Re: New development on site adjacent to 44 Ferringham Lane, Ferring.
Your ref: FG/50/21/PL

Following the approval of application FG/50/21/PL, we have now attached our application for non-material amendments. The amendments for which we seek approval include the following:

DRAWING TITLE
Unit 2
Proposed Plans and Elevations

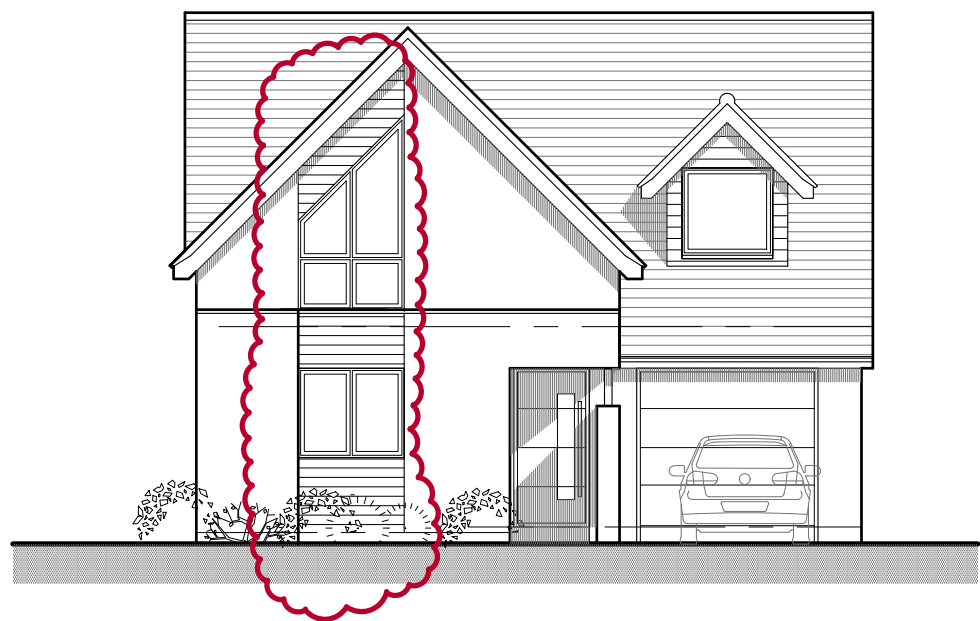
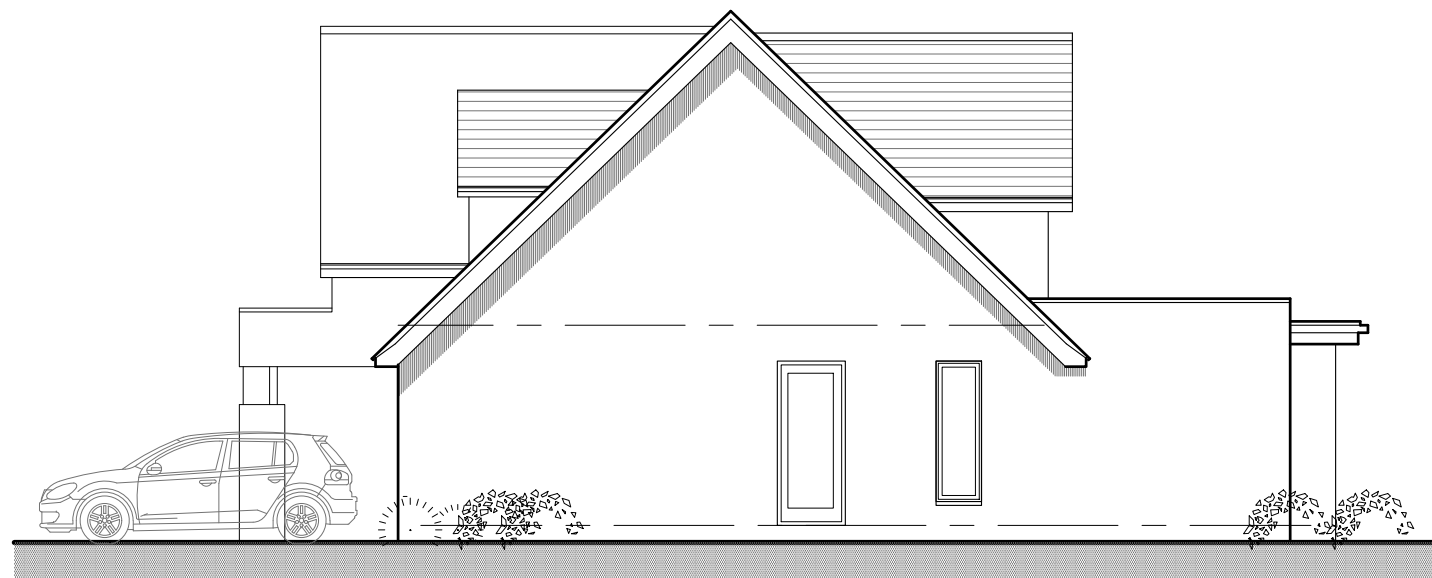
- Plot 1 – Amendments to front elevation. On the approved drawing this was incorrectly shown and did not accord with the floor plan and street elevation. We have attached revised drawing 2007-2.01 revision C
- Plot 2 – Amendments to front elevation. An area of timber boarding has been added to the front elevation. We have attached revised drawing 2007-2.02 revision C
- Plot 4 – Amendments to garage design. The areas of cladding adjacent to the garage doors have been changed from timber boarding to stacked slate cladding to match the front elevation of the house. We have attached our revised drawing 2007-2.04 revision B
